**Cory REP Deadline 7**

**Appendix A: Schedule 1 GLA response to Applicant's submissions at Deadline 4**

**Response to Draft DCO (Rev 3) (with tracked changes) Document 3.1**

WORKS PLAN

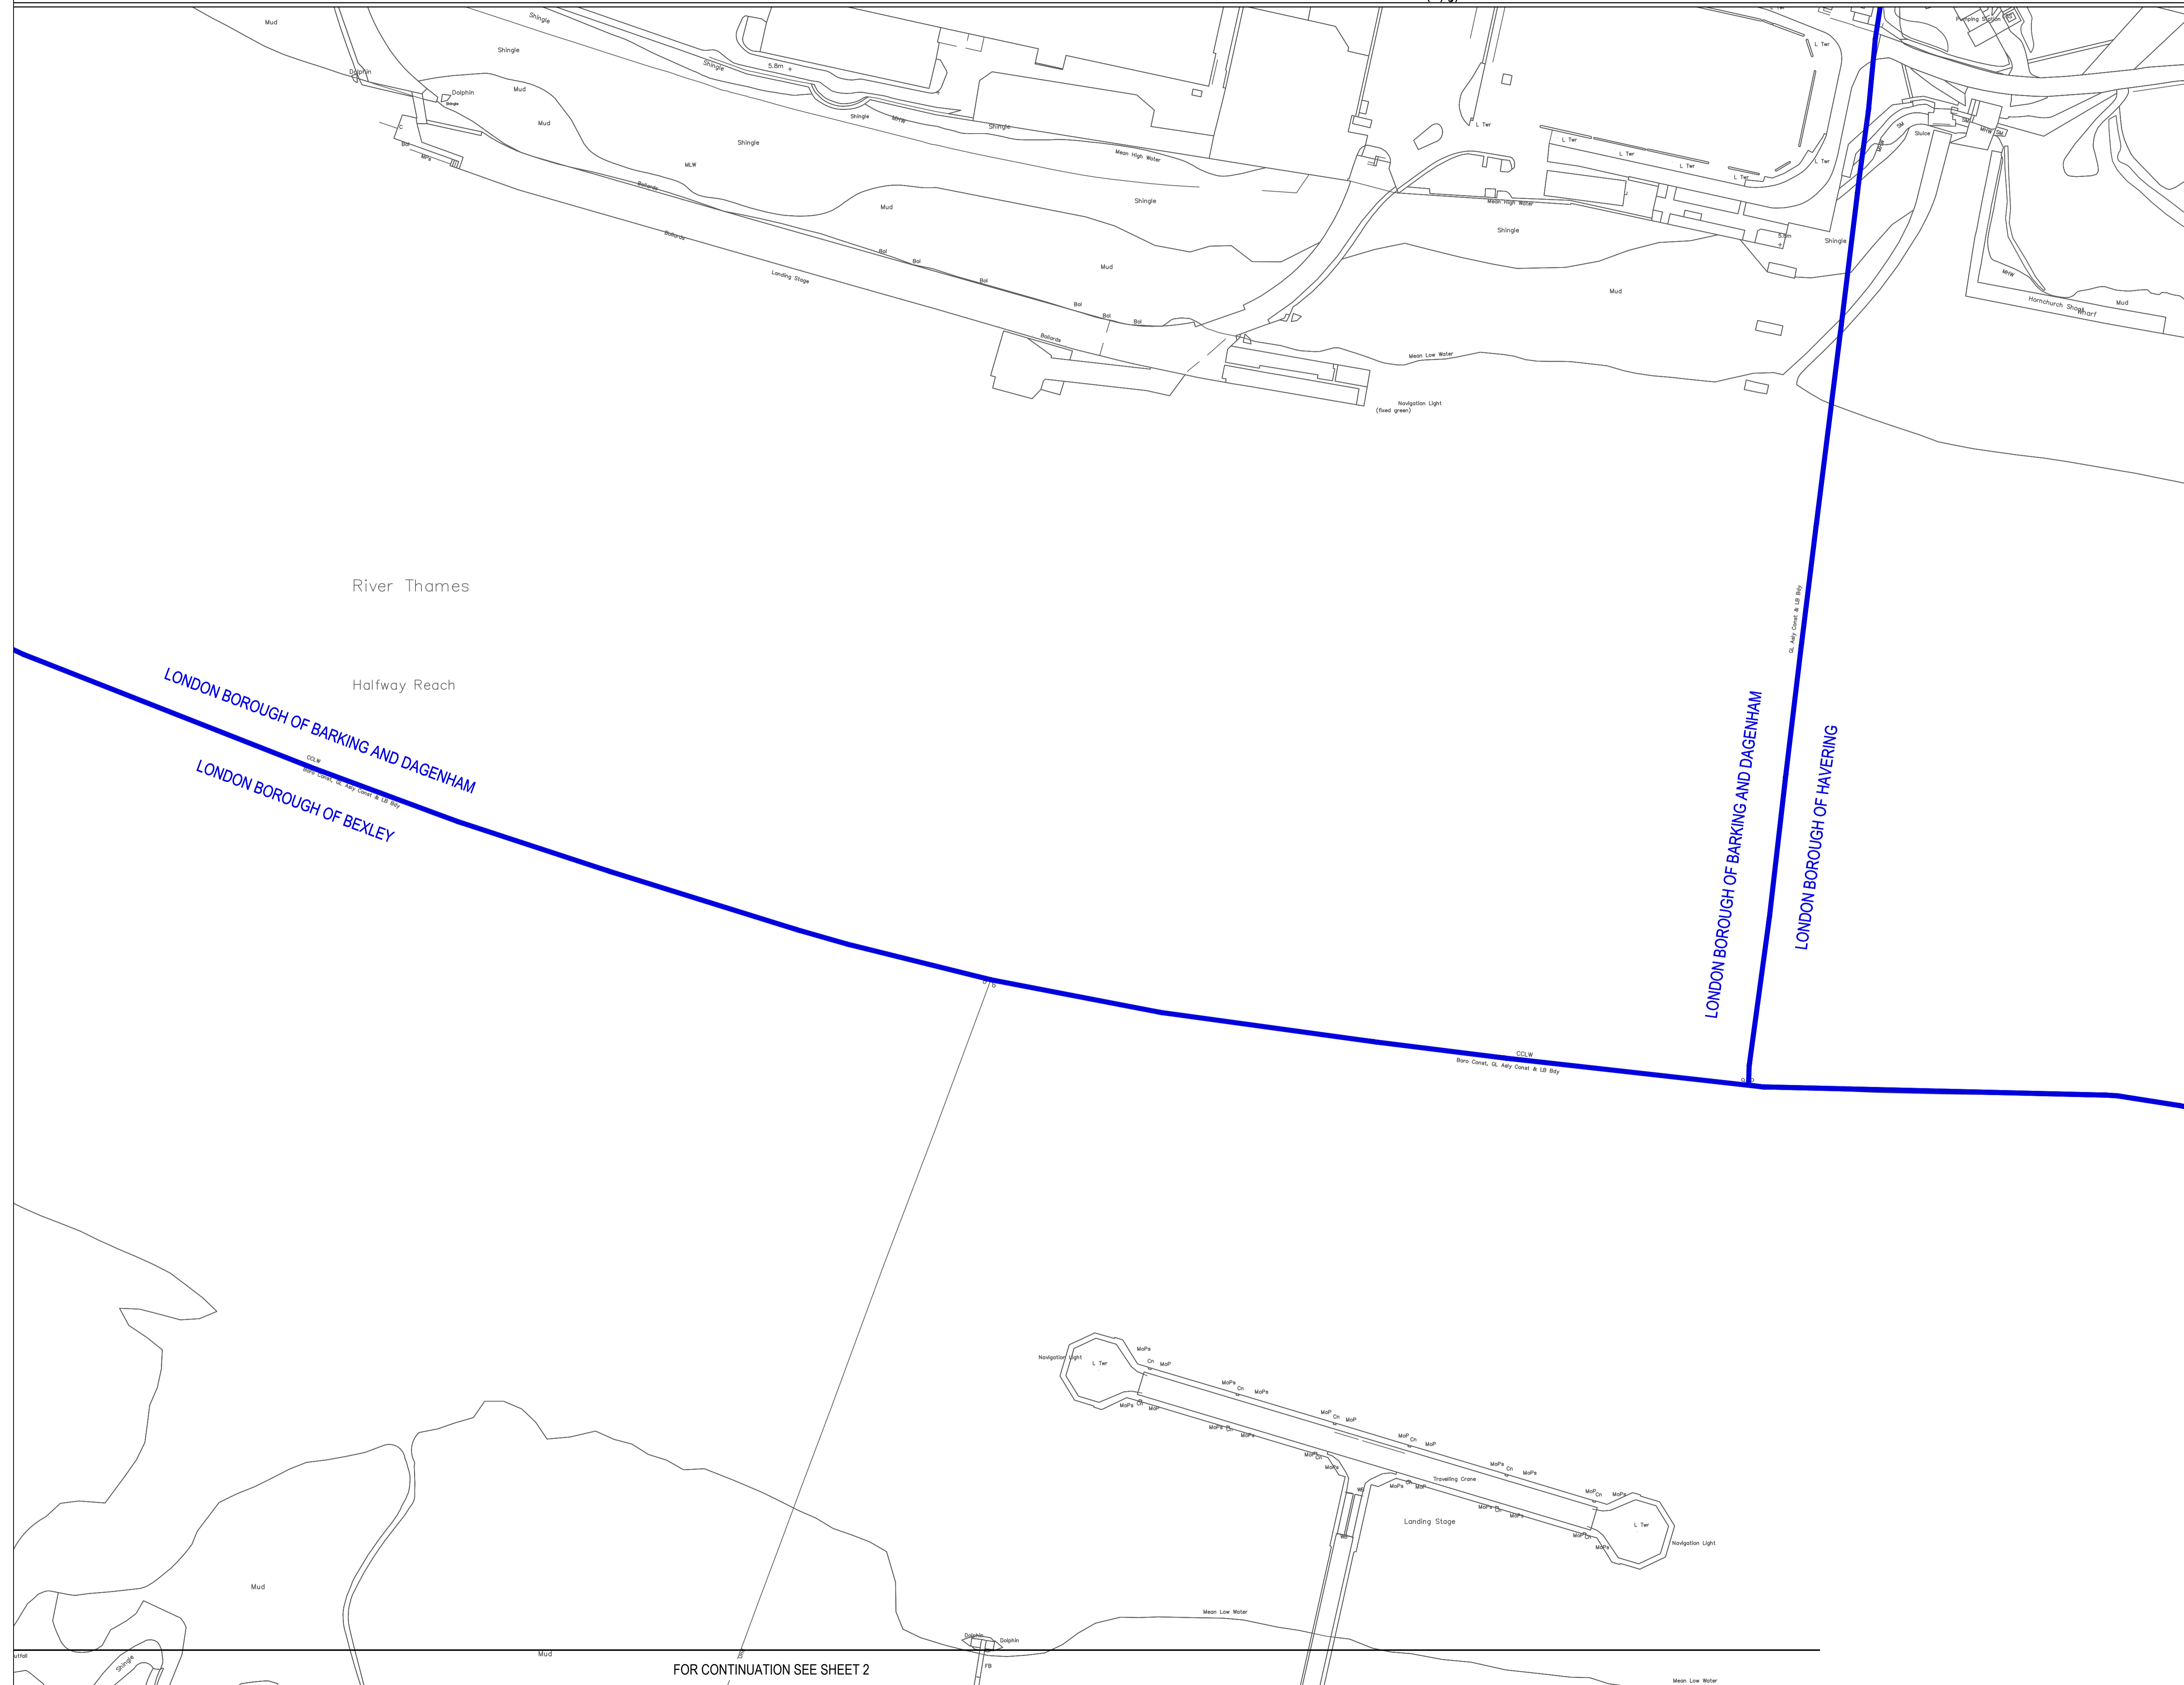
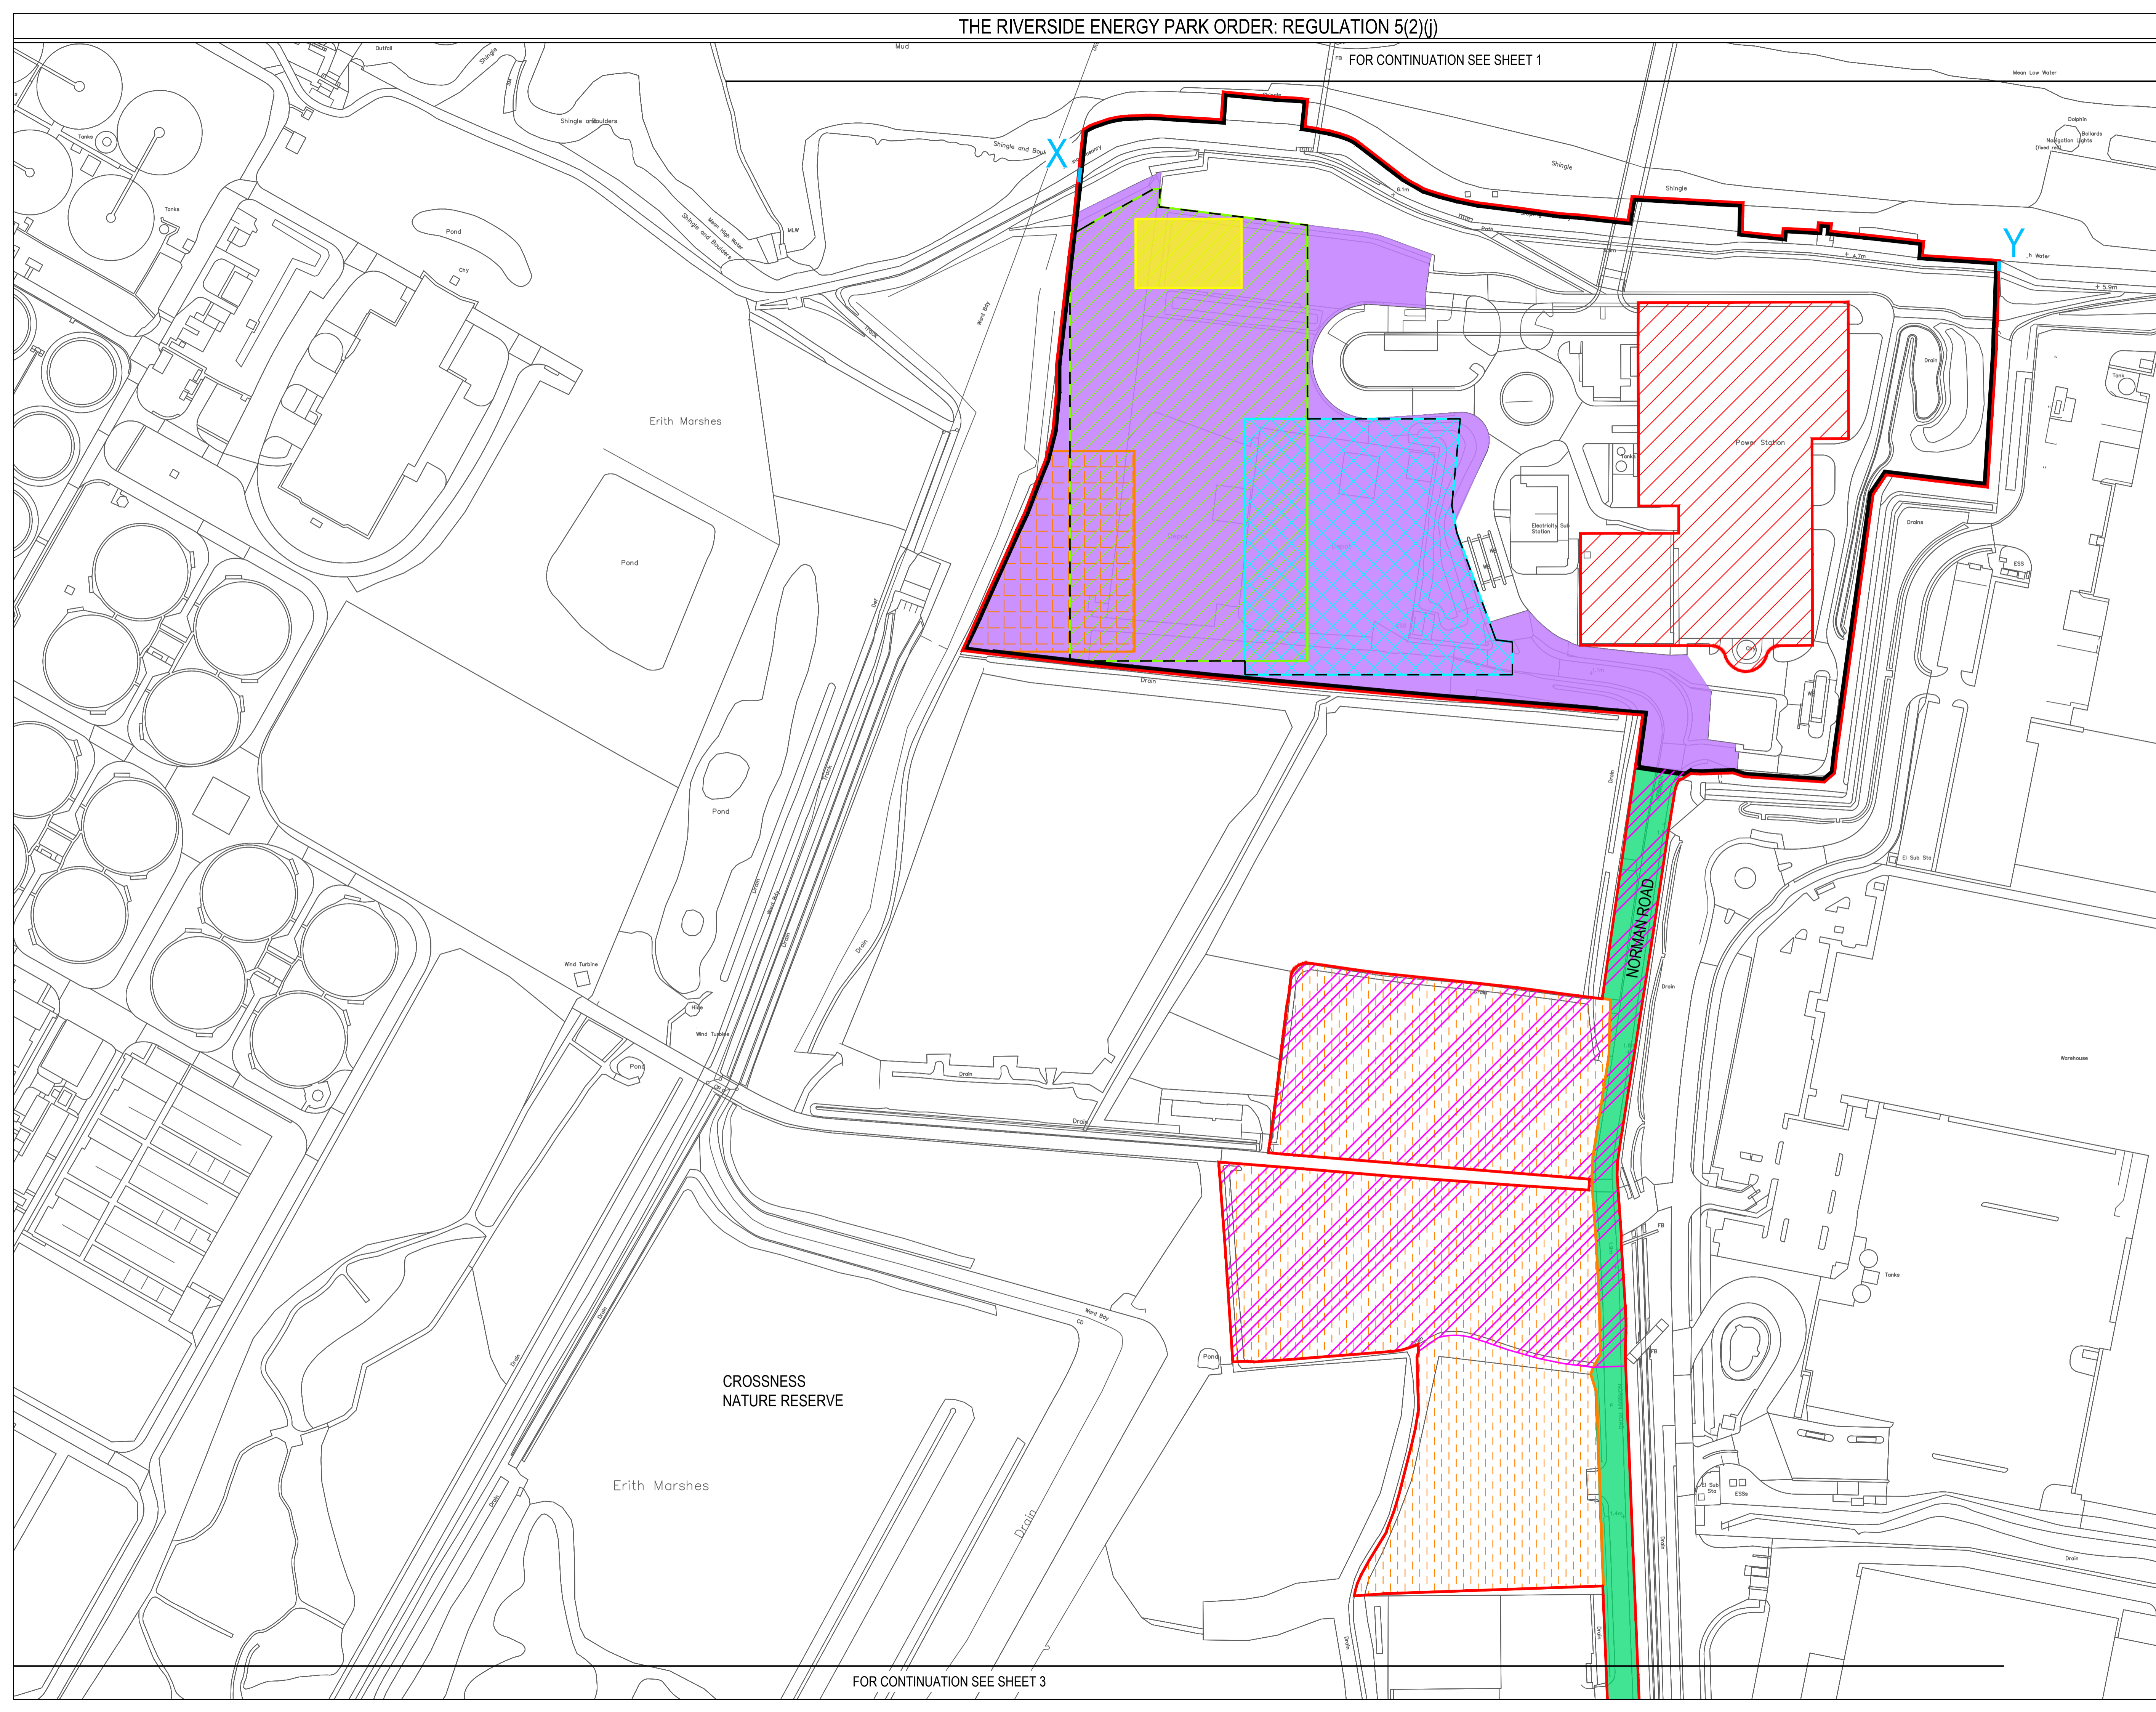
Applicant comment	GLA/TFL comment
<p><b>Draft DCO (Rev 3) (with tracked changes)</b></p> <p><b>Document 3.1</b></p>	
<p><b>1</b></p> <p><b>Schedule 1</b></p> <p>Work No. 1A (v) provides for <i>“a steam turbine and electrical generator (if not constructed and installed as part of Work No. 2).</i></p> <p>Work No. 2 (b) provides for: <i>“ if not constructed and installed as part of Work No. 1A, a steam turbine and electrical generator and a steam turbine building to house all or part of the same”.</i></p> <p>Work No. 3 provided for <i>“Works to construct and install combined heat and power equipment including heat exchangers, pipework (including flow/return pipework, valving, pumps, pressurisation and water treatment systems)”.</i></p> <p>Work No. 6 provides for <i>“Works to construct and install supporting infrastructure, including - (a) pipework (including flow/return pipework), cables, telecommunications, other services and associated infrastructure;”</i></p>	<p>Schedule 1 as drafted does not include a clear requirement for heat off-take from the steam turbine nor adequate provision for the associated plant, equipment and pipework. Consequently, the GLA is concerned about its enforceability.</p> <p>The GLA requests amendments to the description of Works to require the undertaker to install a steam turbine with heat off-take and accommodation for the district heating plant and equipment, and safeguard the route for the on-site heat network pipework to the site boundary. This aligns with the principles placed on the NLWA in their DCO.</p> <p>The proposed amendments are as follows:</p> <p>Work No 1A(v), after <i>“a steam turbine...”</i> add <i>“...incorporating a 30 MW heat off-take for district heating...”</i>.</p> <p>Work No 2(b), after <i>“a steam turbine...”</i> add <i>“...incorporating a 30 MW heat off-take for district heating...”</i>.</p> <p>Work No. 3, the Applicant should be required to show the extent of the Work (flow/return pipework valving, pumps, pressurisation and water treatment systems) on the Works Plan to ensure sufficient space has been provided.</p>

Work No. 6, the Applicant should be required to show a safeguarded route for the flow/return pipework from Work No. 3 to the site boundary on the Works Plan.
<b>2</b>	<p><b>Requirement 14: HCV movements</b></p> <p>New subsection (2): <i>“(2) Save in the event of a jetty outage, the volume of waste delivered by road to work number 1A and work number 1B during commissioning and the operational period must not exceed 240,000 tonnes per annum”.</i></p>	<p>The GLA welcomes the Applicant’s new proposal to apply a limitation to the volume of waste delivered by road. However, it remains concerned about the quantum of waste (200,000tpa of residual waste) that would not be required to be delivered by river. At c. 30% of total inputs on the nominal case, this undermines the stated intention to maximise river transport, and falls short of the minimum 75% of total journeys to come by river, which applies to the RRRF DCO and was requested by the GLA at Deadline 3 - Sheet 4: GLA commentary on other documents prepared by the Applicant for Deadline 2. The 30% road-based limit does not appear to be justified in relation to the quantity of waste that could be sourced from the local area (Bexley).</p> <p>The GLA would not support the Applicant’s proposed road-based limitation on the basis that London Borough of Bexley (LBB) is proposing a cap of 10% of the nominal throughput by road, i.e. 65,500tpa. LBB is concerned that a higher volume would draw in waste deliveries by road from a wider area, as well as potentially impacting recycling activities in Bexley. For further discussion on this point, please refer to comments below in respect of Applicant’s response to GLA and LBB comments on the draft DCO, requirement 14.</p>
